KITTITAS COUNTY

MEMORANDUM

TO: All Staff
FROM: Public Works Plan Review Team
DATE: December 3, 2024
SUBJECT: BL-24-00024 Maxfield

KITTITAS COUNTY		WASHINGTON	
DWN BY	DATE	JOB NO.	
D.L.P./G.W.	12/2024	212402	
CHKD BY	SCALE	SHEET	
D.L.P.	1" = 100'	1 OF 2

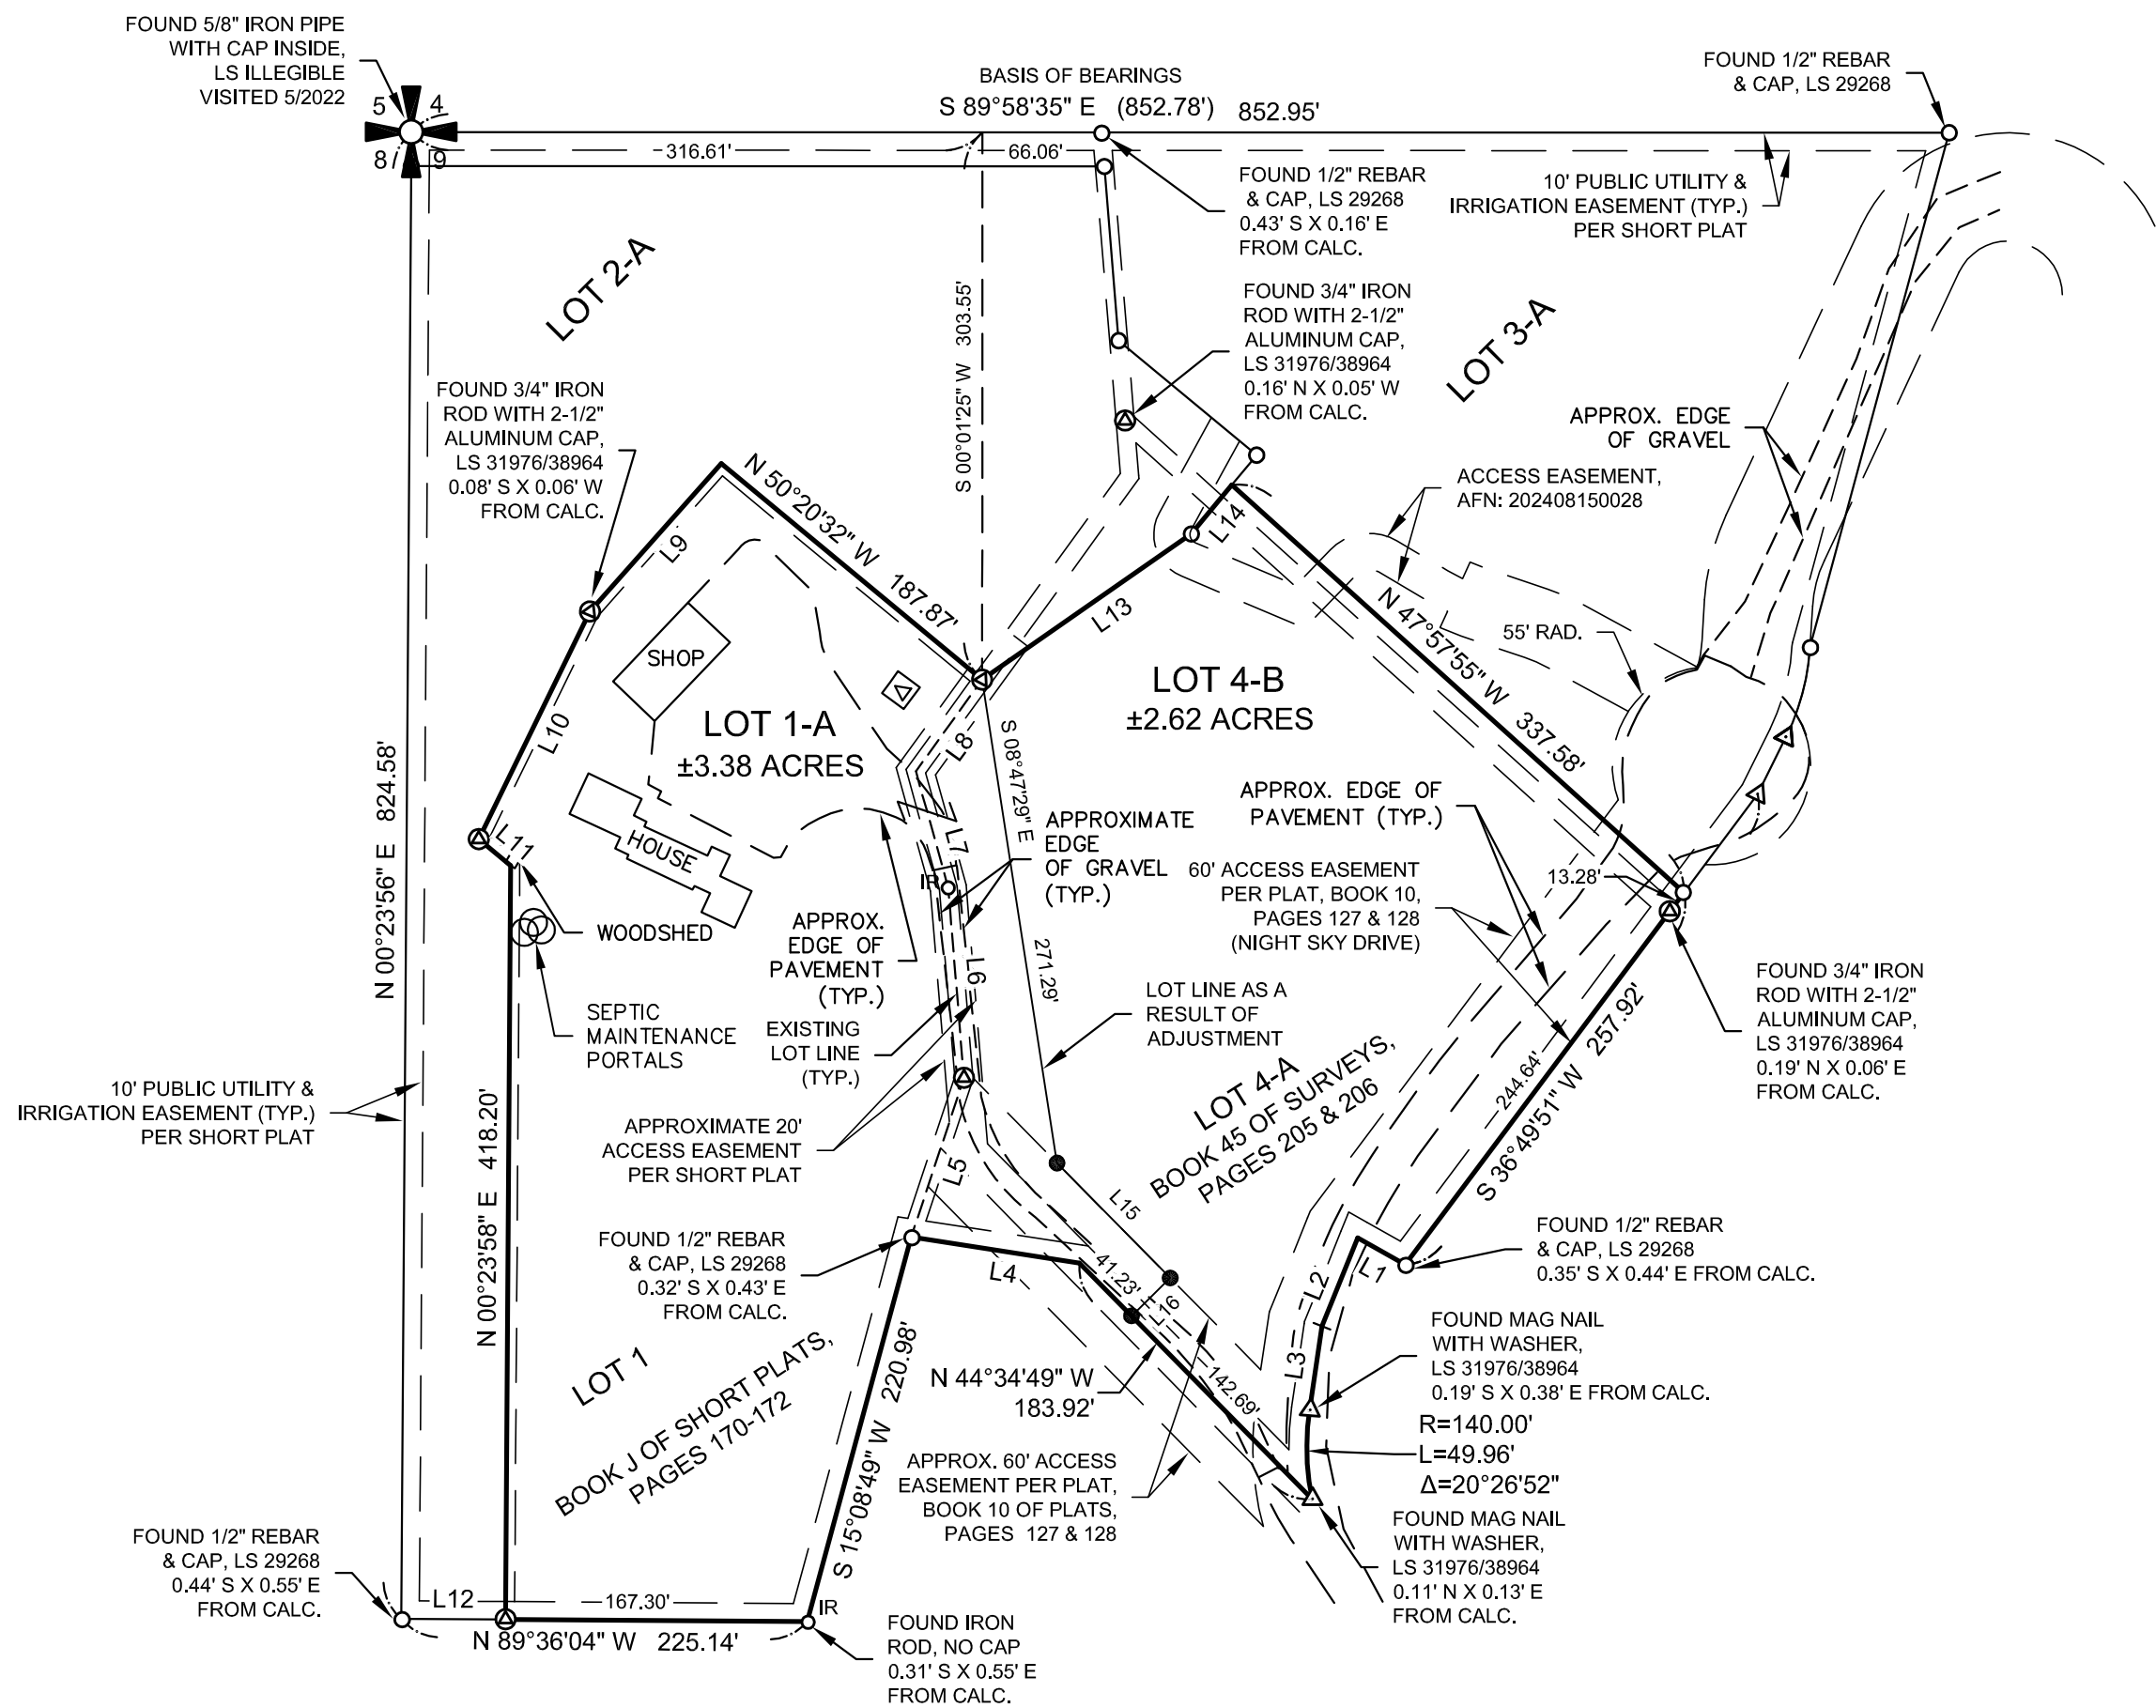
SURVEY	<p>The submitted map is suitable for prelim BLA review. The following comments are in regards to the final survey.</p> <ol style="list-style-type: none">1. At a minimum, the new division line between parcel should be staked in the field and set corners shown on the face of the map.2. In the proposed legal descriptions there is a typo, referencing Lot "3-A" rather than Lot "2-A" (4 occurrences). <p>Of Note</p> <p>Multiple found corners are shown with coordinate differences between found and calculated positions. While a surveyor would naturally presume that these values are from the calc position to the found corner, a general member of the public may think the inverse. Applicant MAY want to consider adding language such as "0.1'Nx0.2'E of calc" or "0.1'Nx0.2'E from calc" to clarify.</p> <p>UPDATE 12/13/2024</p> <p>The resubmittal addresses all previous comments except Comment #2 above. The proposed legal descriptions contain 4 references to Lot 3-A. In retracing the boundaries, it is clear that these should be referencing Lot 2-A. (JT)</p>
